Re: Proposed development of a resource recovery centre (including waste-to-energy facility)
in Ringaskiddy, County Cork.

Submission to An Coimisiún Pleanála — Case PA04.318802

Submission re the Community Health Impacts of the Proposed Indaver Hazardous Waste and Waste-to-Energy Incinerator, Ringaskiddy, Co. Cork

Figure 8.4 Cork Airport Windrose 2021 -2025

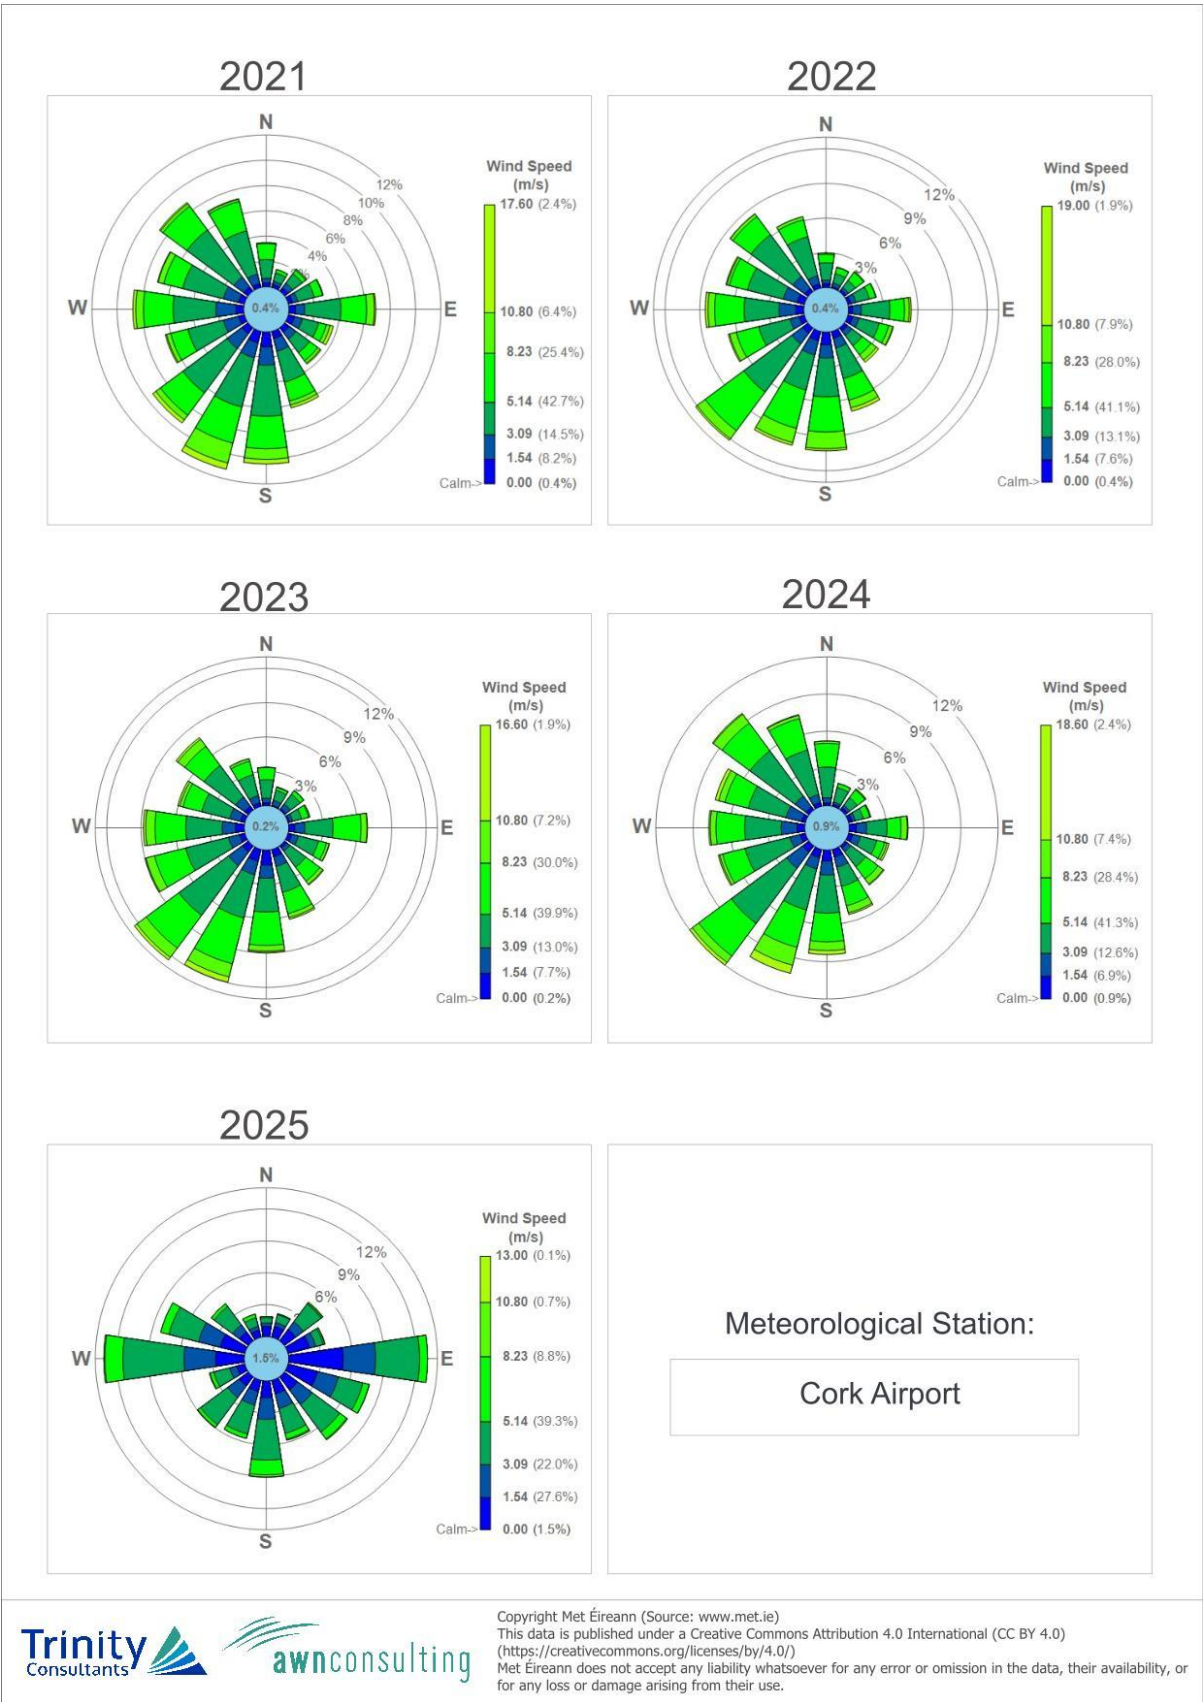
4. Invalid meteorological data submitted by Indaver : Use of Cork Airport data (~15 km inland and west of the site) fails to capture local sea-breeze inversions and weather conditions in Ringaskiddy. This can underestimate real local exposure.

- The Environmental Impact Assessment (EIAR) uses Cork Airport meteorological data for dispersion modelling. This station lies approximately 14–15 km from Ringaskiddy and experiences distinct inland wind regimes.
- Ringaskiddy's coastal and estuarine airflow (sea breezes, inversions) significantly affects pollutant dispersion. Using Cork Airport data without correction likely underestimates local ground-level pollution.
- An Coimisiún Pleanála should require site-specific meteorological measurements for at least 12–24 months before accepting any dispersion or health conclusions.

- Commission an independent Health Impact Assessment (HIA) reviewed by experts in environmental medicine, developmental toxicology, and particle toxicology.
- Require on-site meteorological monitoring (≥ 12 months) before final assessment.
- Implement UFP monitoring (particle number concentration) at fence-line and community sites, with open public reporting.
- Conduct biomonitoring (maternal/cord blood, food chain sampling) for persistent pollutants.
- Require real-time public reporting of PM_{2.5}, PM₁₀, NO_x, and UFP data.
- Establish an independent community oversight group for emissions and health monitoring.
